Our ref: HA/2014/116106/01-L01
Your ref: BE/95/14/DOC
Date: 17 September 2014

APPLICATION FOR APPROVAL OF DETAILS RESERVED BY CONDITIONS 3 (SURFACE WATER DRAINAGE) AND 6 (SUSTAINABLE DRAINAGE PRINCIPLES) FOLLOWING A GRANT OF PLANNING PERMISSION BE/61/13/ OLDLANDS FARM STEYNING WAY BOGNOR REGIS PO22 9NN

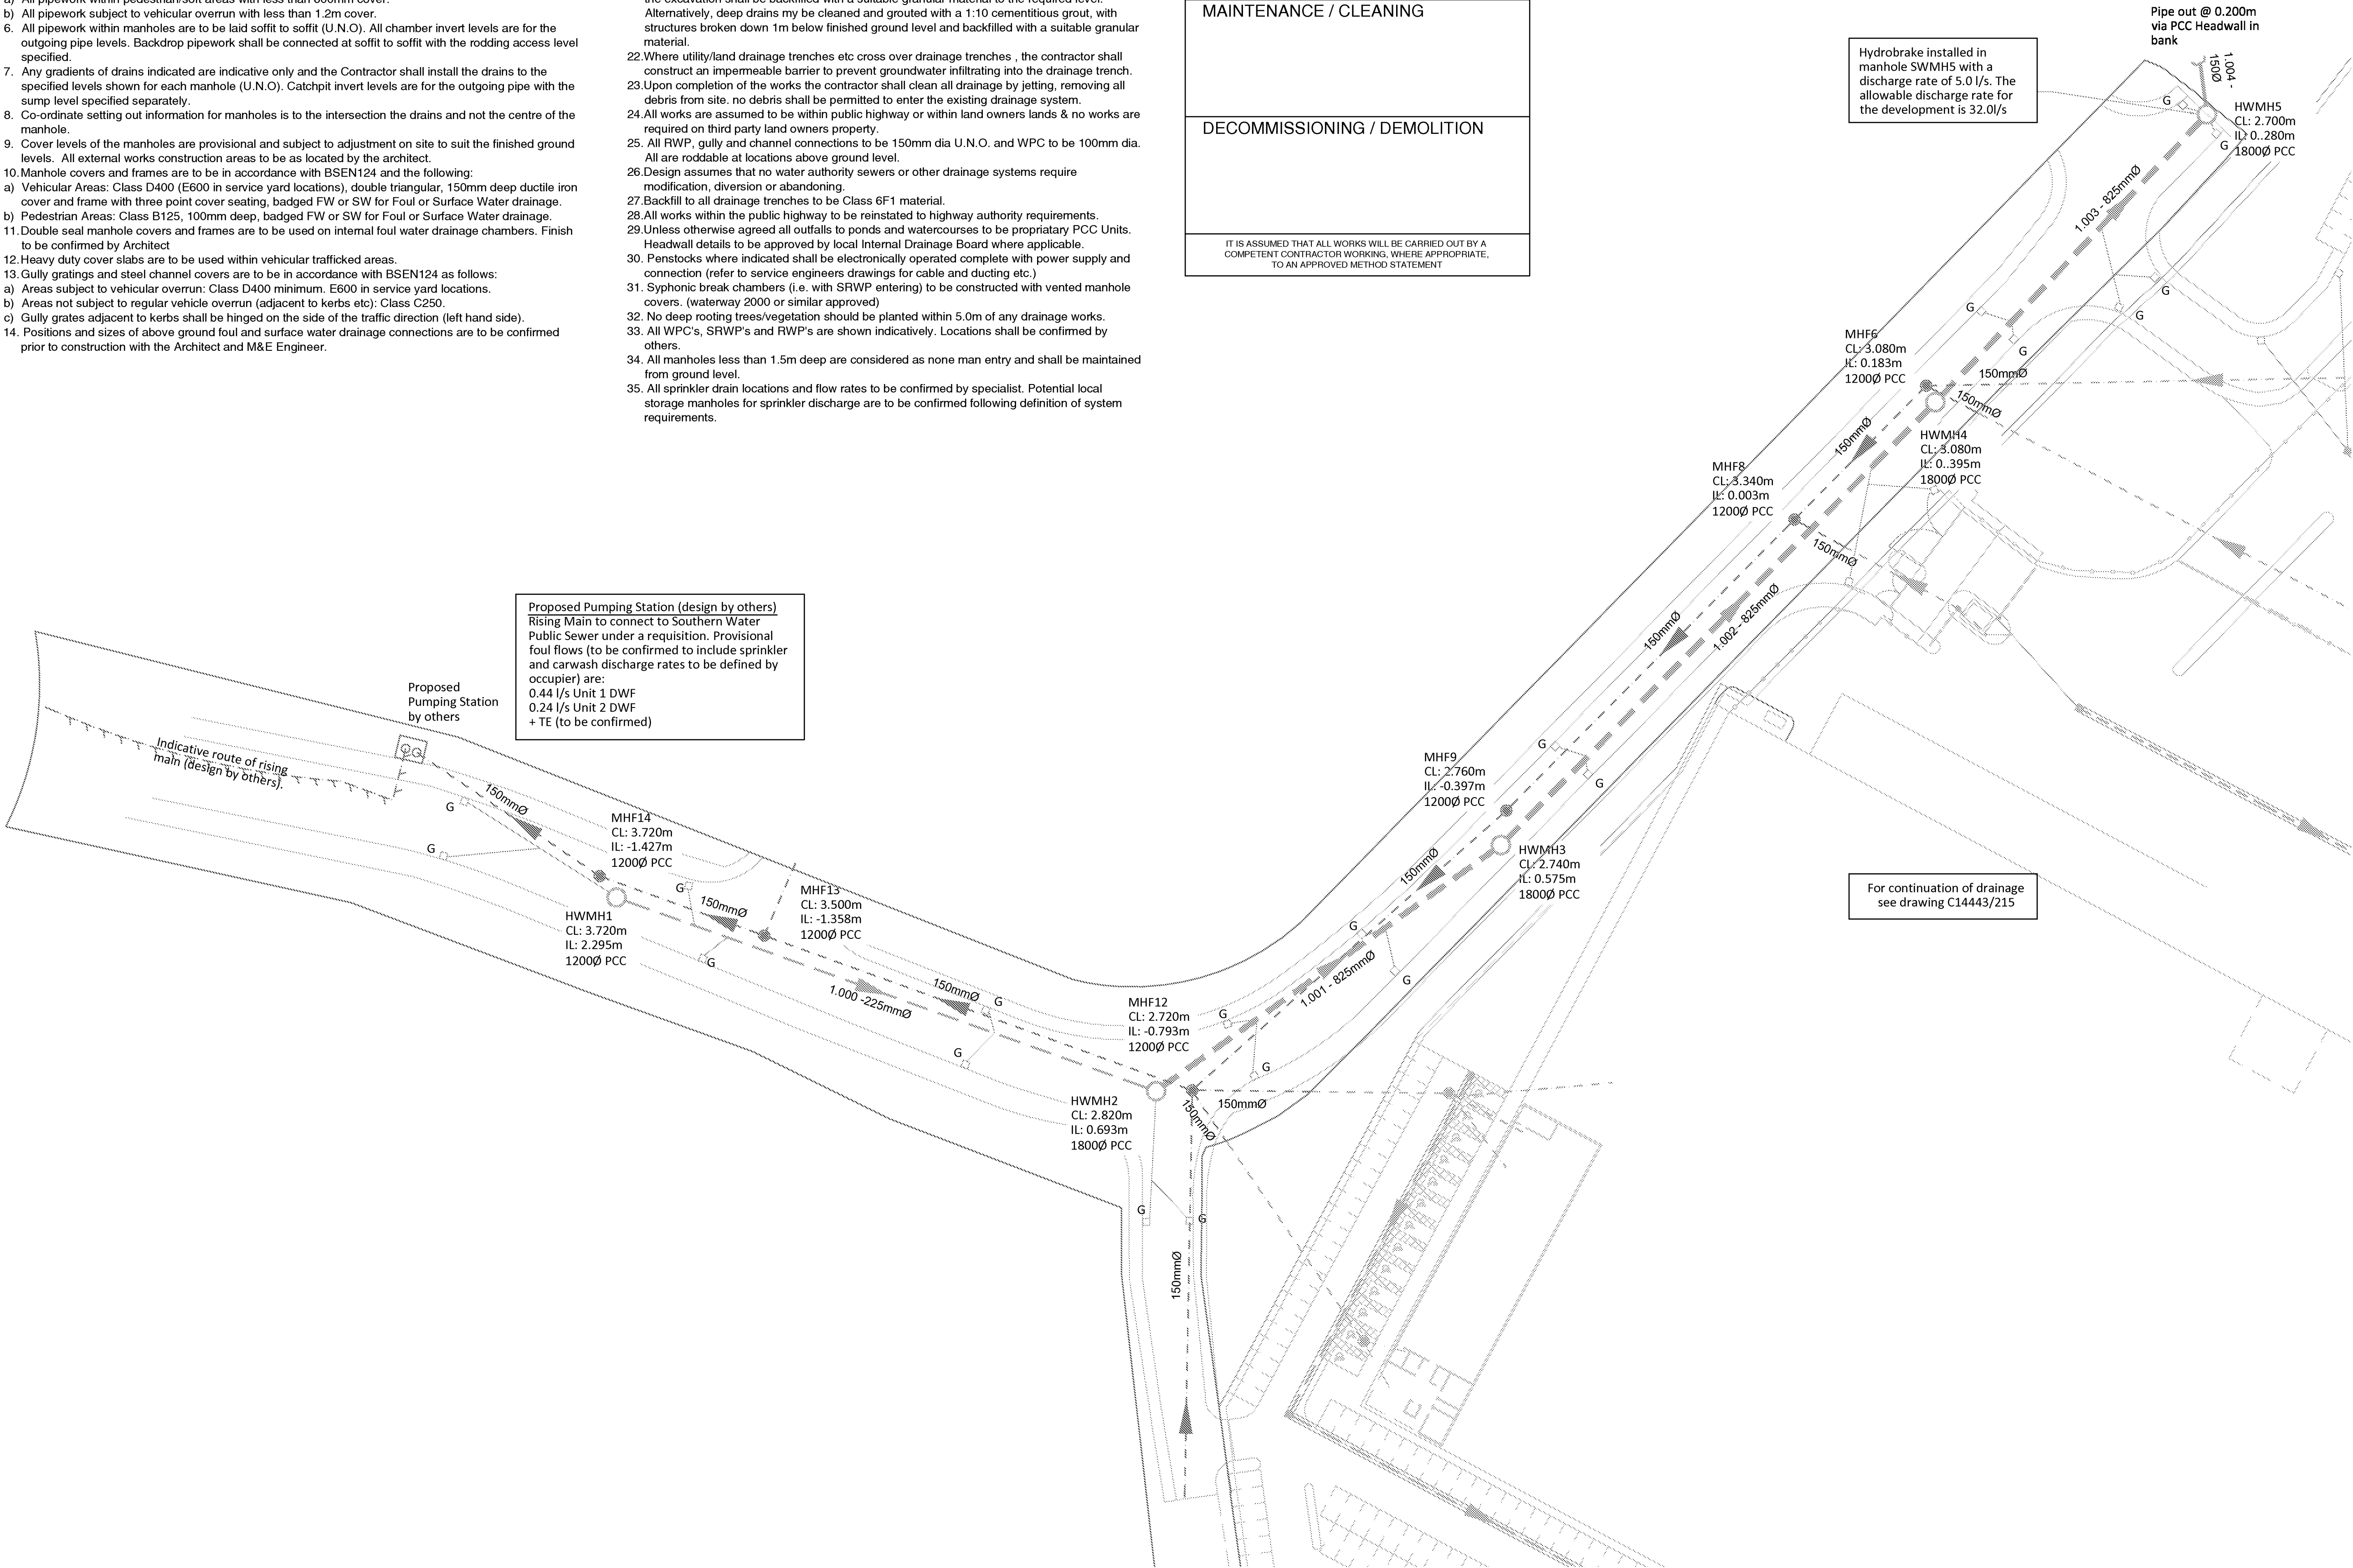
Though the above provides a very brief outline of the pollution prevention measures, there are no specific details of where the interceptors will be placed, what they serve and where they discharge to and no details of their design and capacity.

There is a plan showing the access road with trapped gullies draining to the hydrobrake. However there are no details to state whether these devices are a sufficient means for pollution prevention and where the surface water drains to after the hydrobrake .
